Submission to Hills Showground Concept DA 191204 / SSD 5693

As a resident of Castle Hill for the last eighteen years and residing at our property 32 Carrington Road I have read the Concept DA and wish to raise three issues within its contents and plans.

Drawing Title
Site and Development Lots Plan

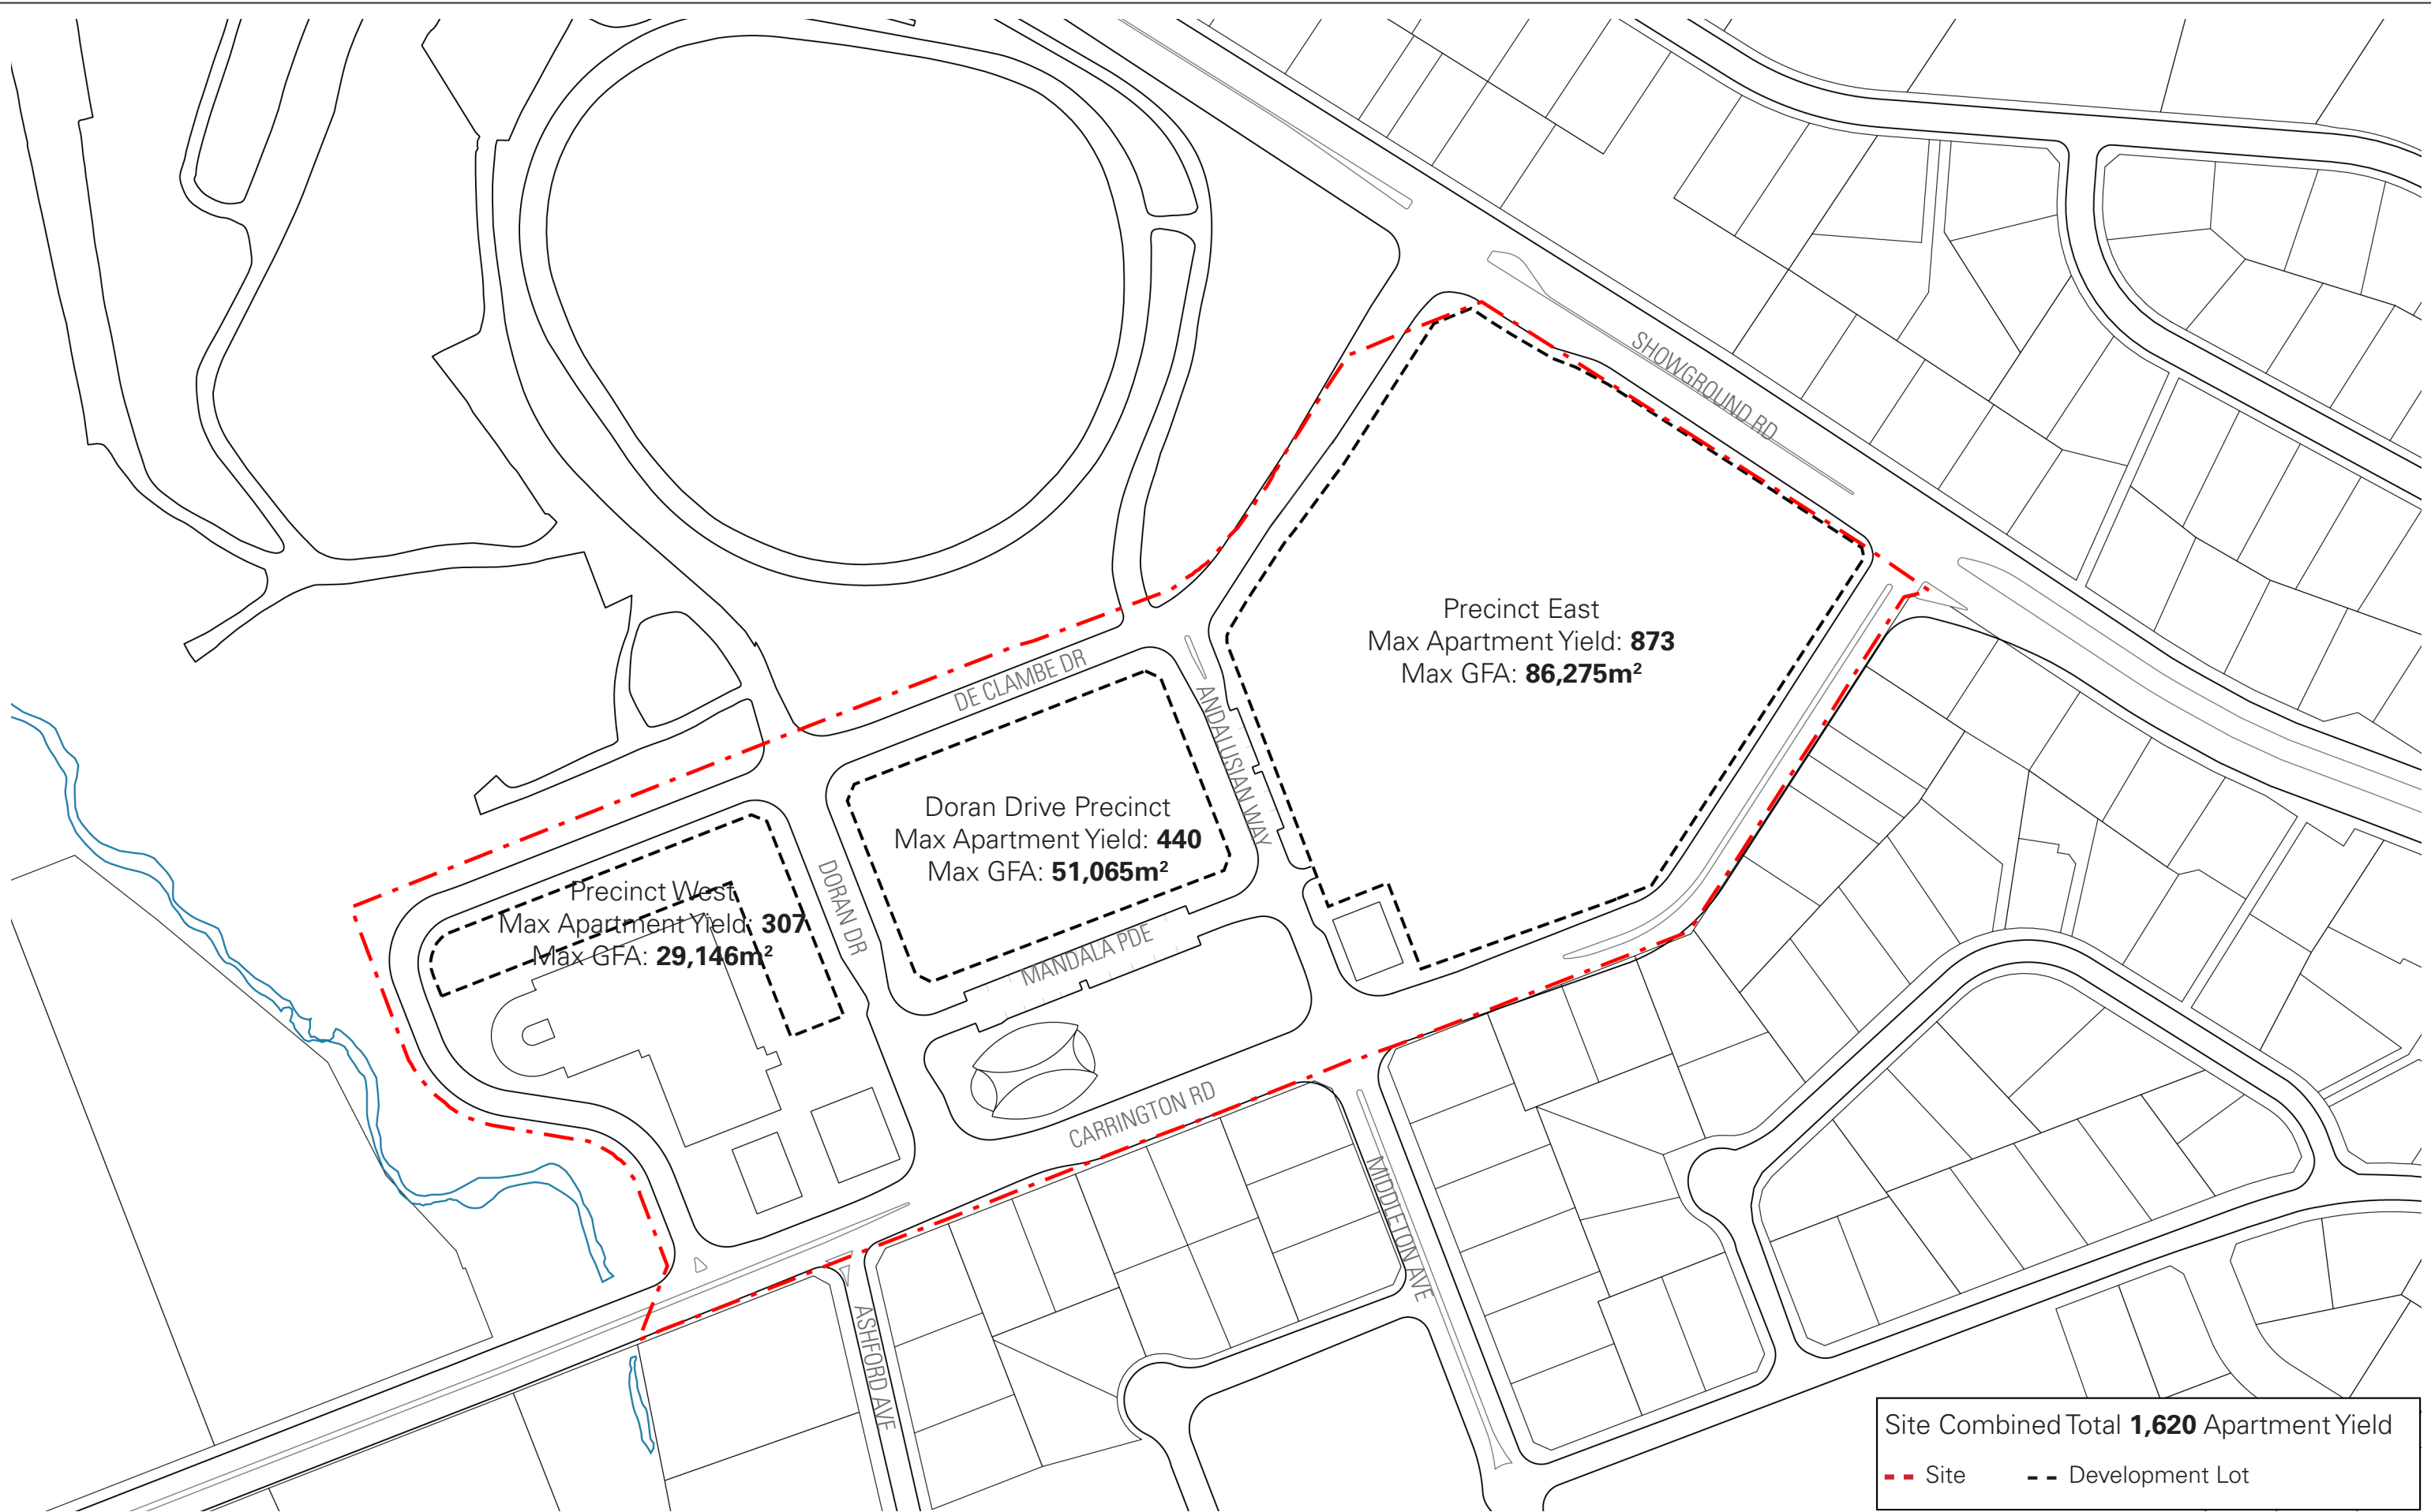
The central Doran drive plaza lots are sized below 3600m², and are thus unable to comply with The Hills LEP 2012. The LEP has been around since 2012, however no effort has appeared to be taken to comply with this document.

The idea that the 2286M² Lot be comprised of a 20- storey building, displays an attitude of contempt to the residents surrounding the station area with over development. Further, the range of types of units for all three sections doesn't appear to have the same or similar requirements that the Hills council has insisted upon with any other potential developer that has made enquiries re properties south of Carrington road. This has highlighted an unequal set of rules and compliance parameters between government owned and private land holders. The buildings in the west section closest to the car park, don't appear to have any set back from the footpaths, an area of often voiced concern by numerous councillors with all new high-density developments.

The Hills Showground Metro Station is located within the Hills Showground Precinct. Under Clause 9.1 of The Hills LEP 2012, residential flat buildings taller than 11 metres are required to have a minimum lot size of 3,600m². The proposal seeks concept approval for subdivision into 3,293m² and 2,286m² lots. A variation under clause 4.3 of the LEP is provided to justify the development of residential flat buildings on the undersized lots.

Clause 9.7 of the LEP mandates a minimum 10,000m² lot size to enable development with an FSR between 2.3:1 and 3.1:1 on the southern side of Carrington Road. No reasoning is provided as to why much smaller minimum lot sizes and much greater densities are permitted on the northern side of Carrington Road. It would appear that there is preferential treatment for government land over privately-owned land. The proposal should be revised to comply with the minimum 3,600m² lot size.
